**Project Name:** Coors & Western Trail Tract 3A

**Project Location:** (address or major cross streets/arroyo)  
4500 Quaker Heights PI NW Albuquerque NM 87120

May 18, 2021

**RE: RESPONSE TO STORMWATER QUALITY COMMENTS  
ATIVO ALBUQUERQUE LLC – 4500 QUAKER HEIGHTS  
EROSION AND SEDIMENT CONTROL PLAN**

ENGINEER'S SEAL	DRAWN BY RG
RONALD R. BOHANNAN NEW MEXICO 7868 PROFESSIONAL ENGINEER	DATE 05/17/2021
TIERRA WEST, LLC 5571 MIDWAY PARK PL NE ALBUQUERQUE, NEW MEXICO 87109 (505) 858-3100 www.tierrawestllc.com	DRAWING 2019064-SWPPP
RONALD R. BOHANNAN P.E. #7868	SHEET # SW-1
	JOB # 2019064

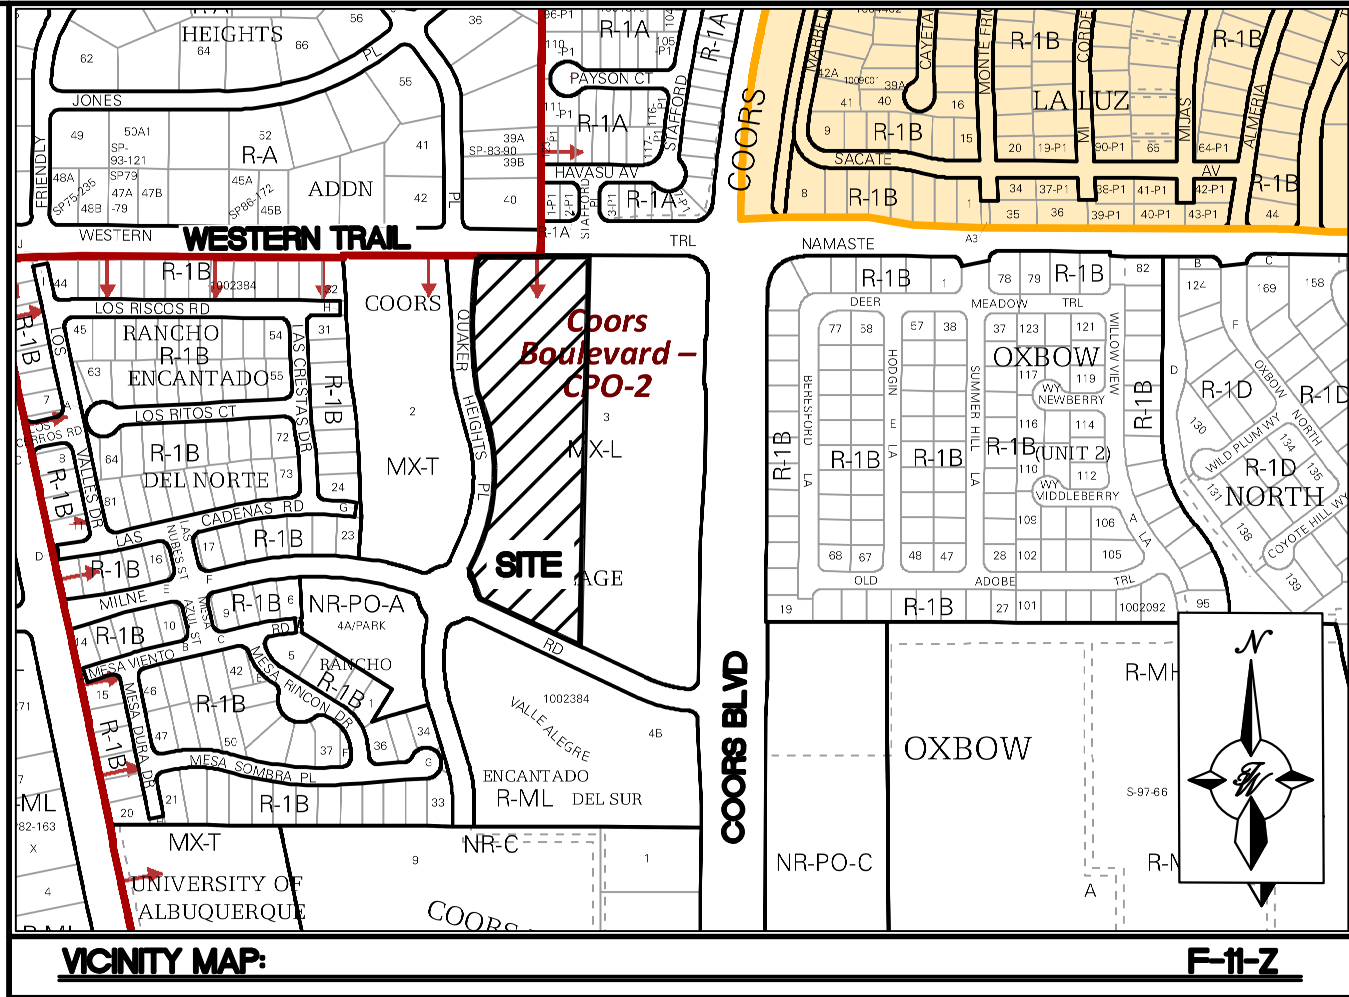
1. The "limits of disturbance" symbol in the legend is not shown anywhere on the plan. Clearly indicate the limits of disturbance. (CGP7.2.4.b.i)  
**Response: The limits of disturbance are now shown on the plan with line work matching that of the legend.**
